ExQ1	Question to:	Question:
2.	Air Quality and Emissions	
2.0.5	NCC, BC, BDC, SNC	ES Chapter 5: Air Quality [APP-044] paragraph 5.4.10, are the parties happy with the approach taken with regards to PM2.5? If not, please explain.
	NCC Response:	District colleagues should be contacted/involved so as able to add more detail about PM10 and PM2.5 calculations as these may feature in their ASR returns. Please note PM2.5 limits may be impacted by the Environment Bill so current non-exceedance may potentially change in the future. Whilst these levels may not be known for certain it may be that WHO levels become a longer-term aspiration.

Norfolk County Council

Identification No: TR010038

DRAWING TITLE
DRAINAGE CATCHMENT PLAN

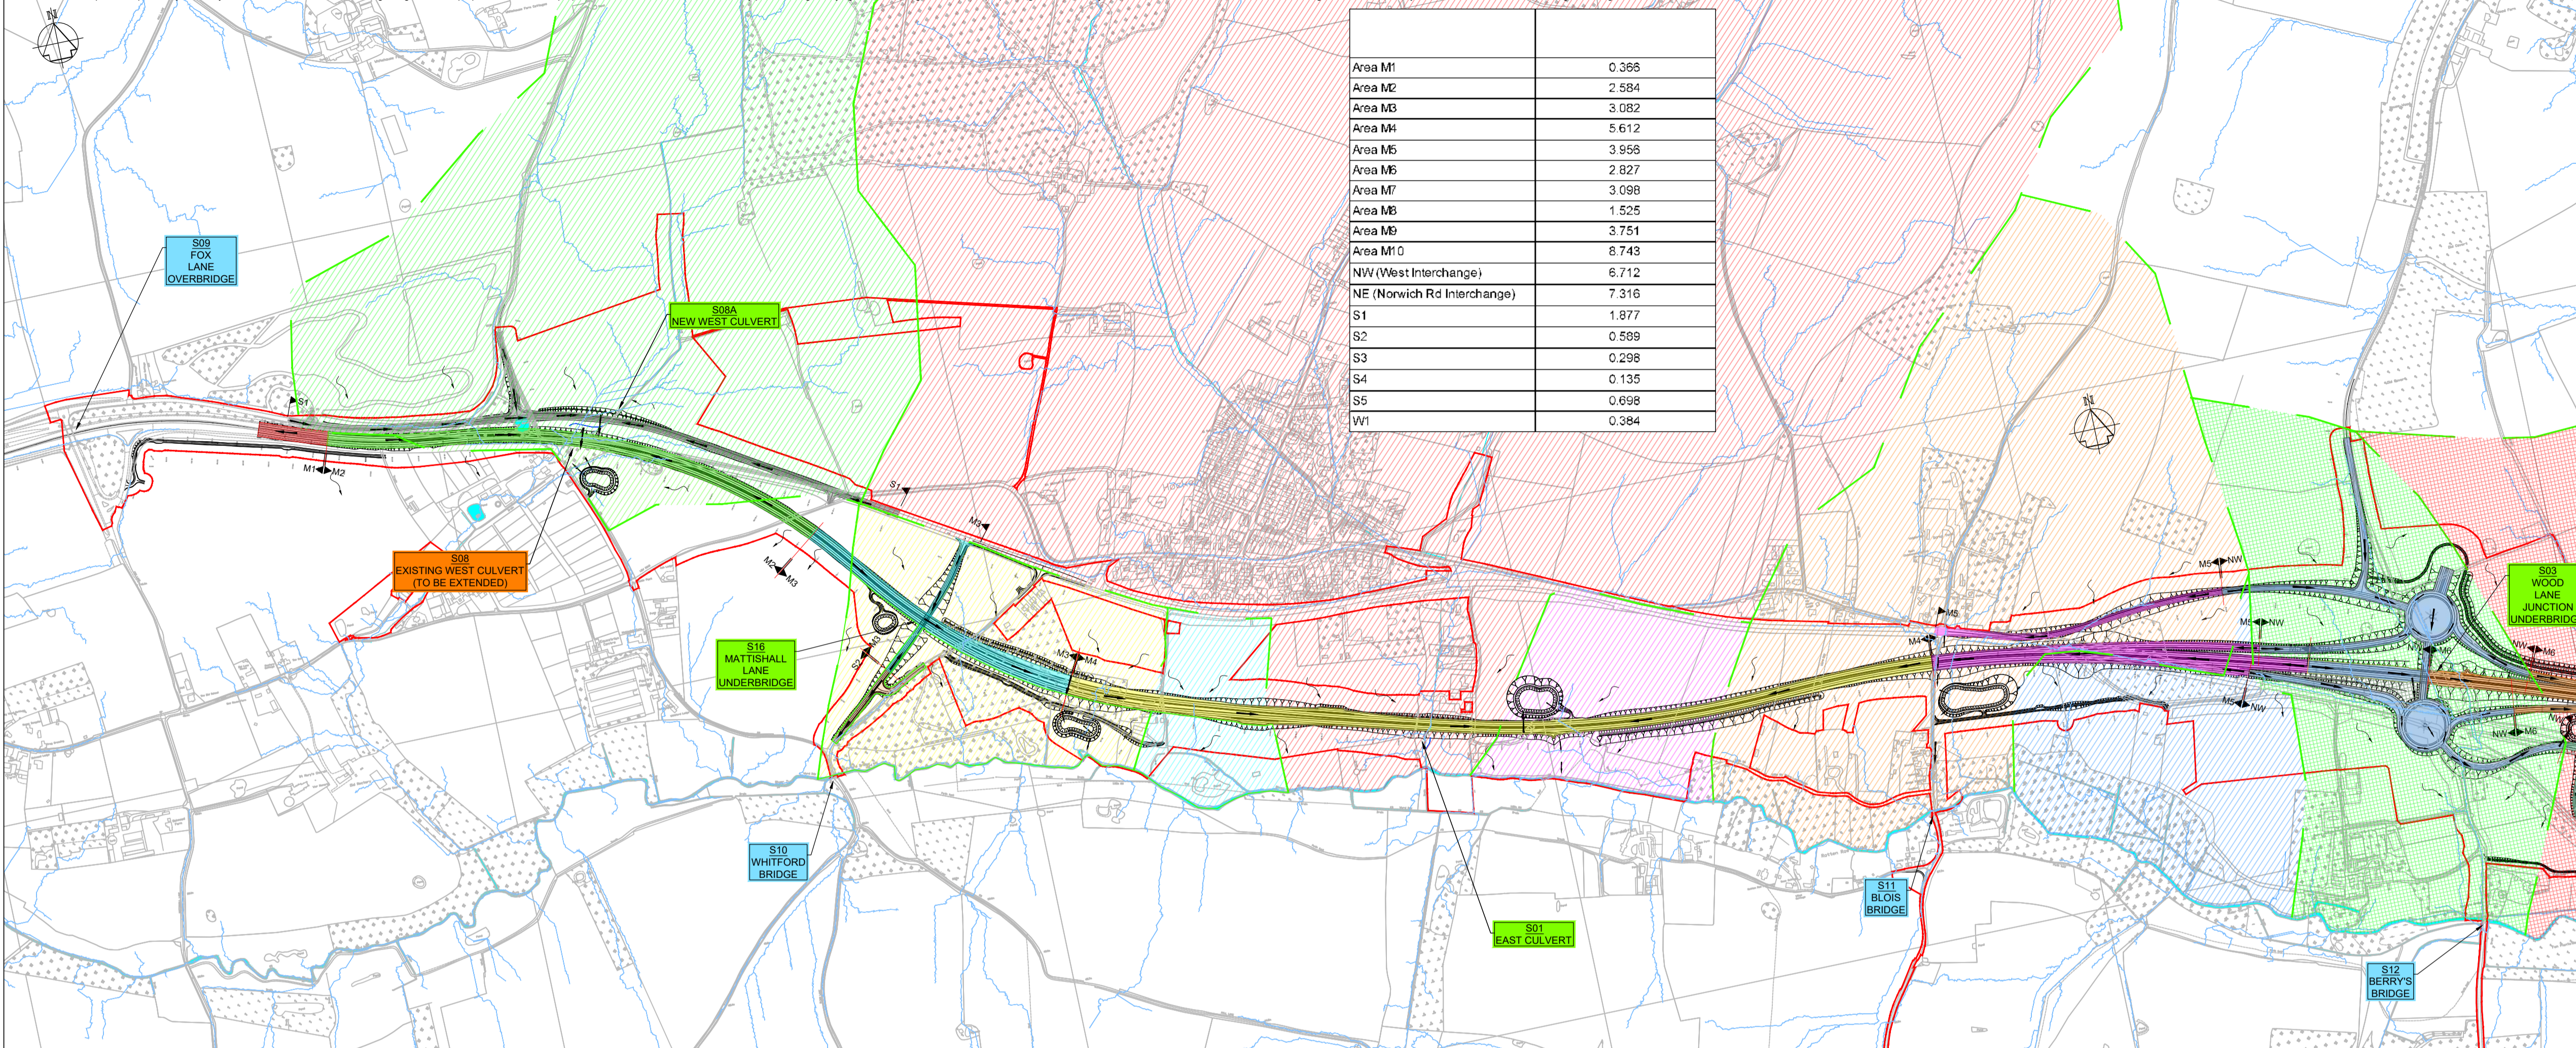
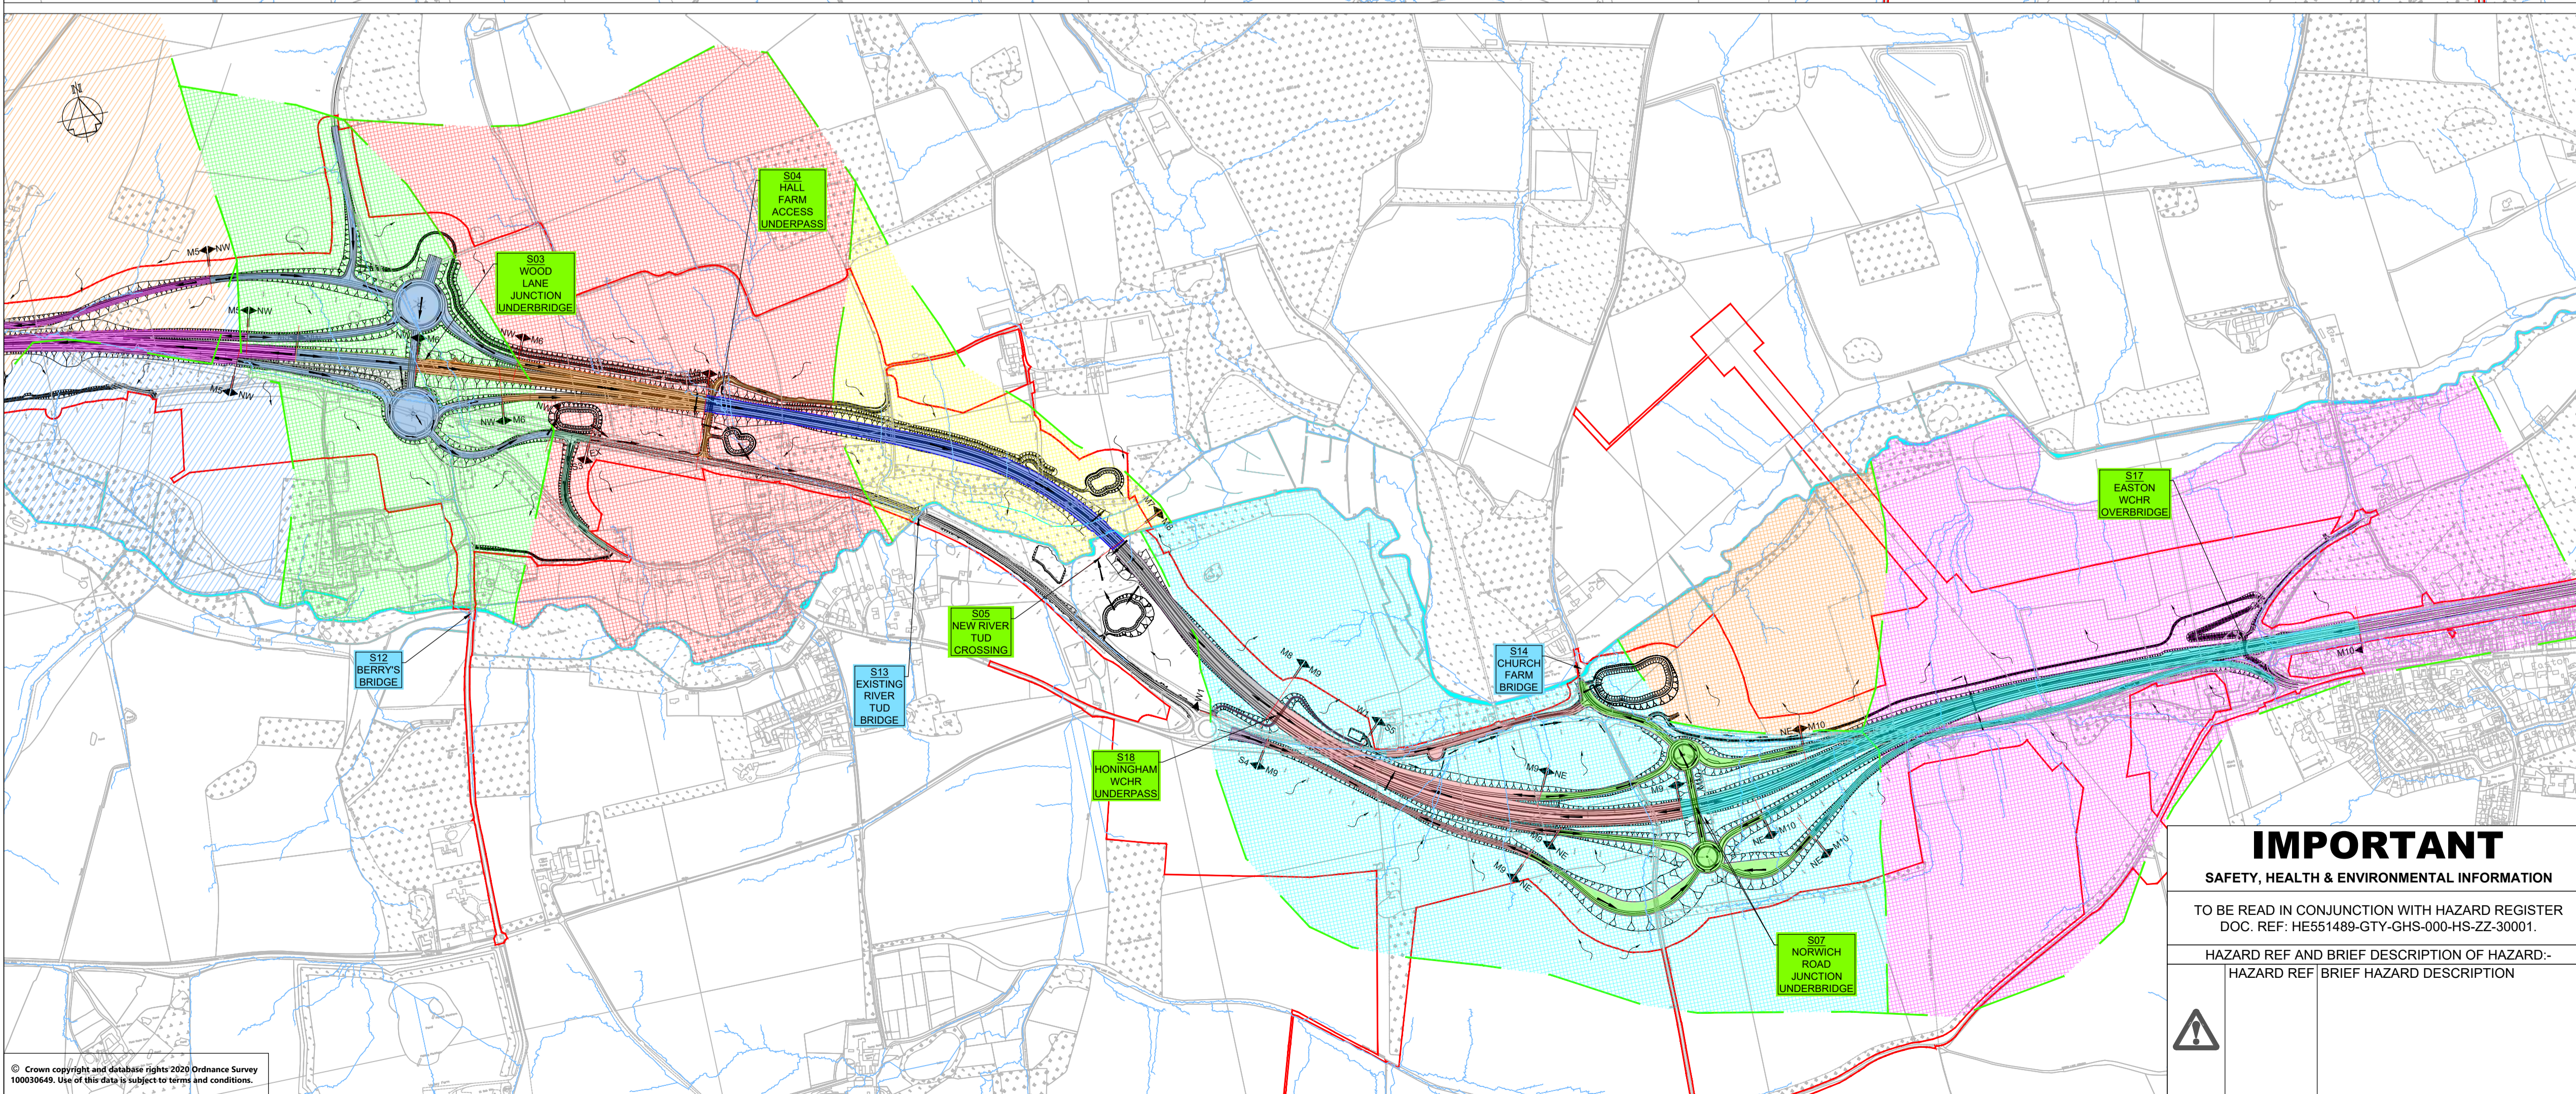
15.0.11	EA, NE, NCC, BC, BDC, SNC	ES Chapter 13: Road drainage and the water environment [APP-052], paragraph 13.9.15 refers to the provision of replacement ponds. Are the parties satisfied that the replacement proposals will deliver the necessary mitigation? Do they provide an improvement to the current situation?
	NCC Response:	The limited information about these ponds in Chapter 13 from a local surface water drainage network perspective and does not clear identify the seven ponds that are to be replaced. From looking at Figure 13.1 (sheets 1 and 2) and the catchment plans in the Drainage Strategy, the ponds are indicated to appear offline

from the local surface water drainage network. However, the chapter acknowledges that the developer's investigations are limited, and that uncharted drainage system may exist.
